SUBJECT: Engineering Review Comment
Mountain View Electric Association Inc. (MVEA)

Project Name: Sterling Ranch East Filing 6 – Preliminary Plan

Project Number: SP244

Description: Proposed development of 198 residential lots located northwest of Briargate Pkwy and Sterling Ranch Rd. in Township 12S, Range 65W, Sections 27 and 34.

**DETAIL: TYPICAL LOT EASEMENTS**

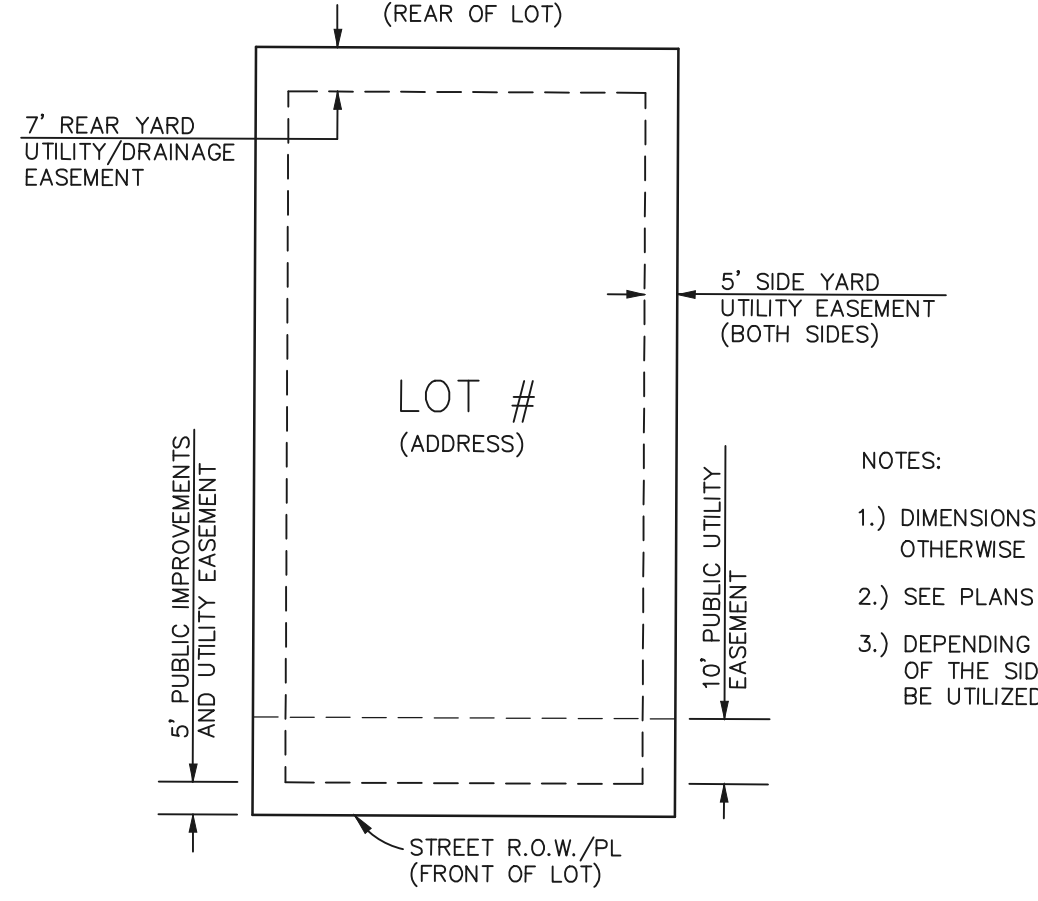
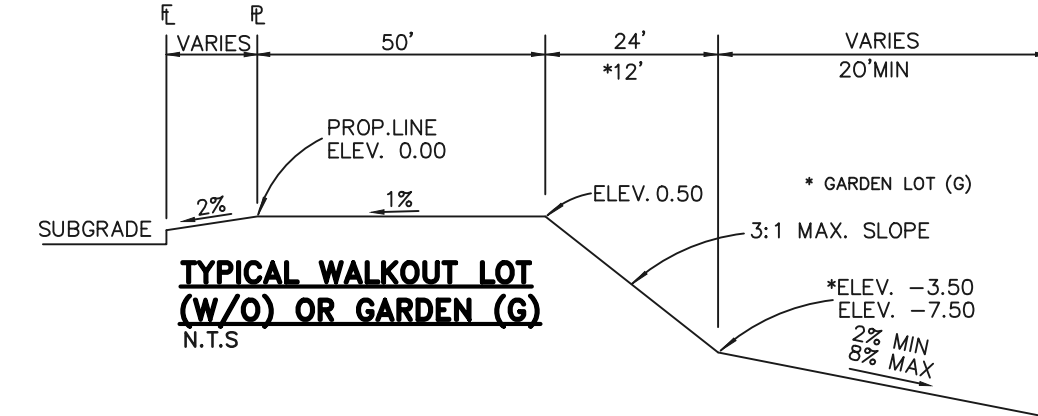
MVEA requests a ten (10) foot front lot utility easement in addition to any public improvement easements, a five (5) foot side lot utility easement, and a seven (7) foot rear lot utility easement along with a twenty (20) foot exterior utility easement on the plat and all tracts include easements. MVEA also requests the platting of MVEA's existing facilities with easements on the plat. Additional easements may be required.
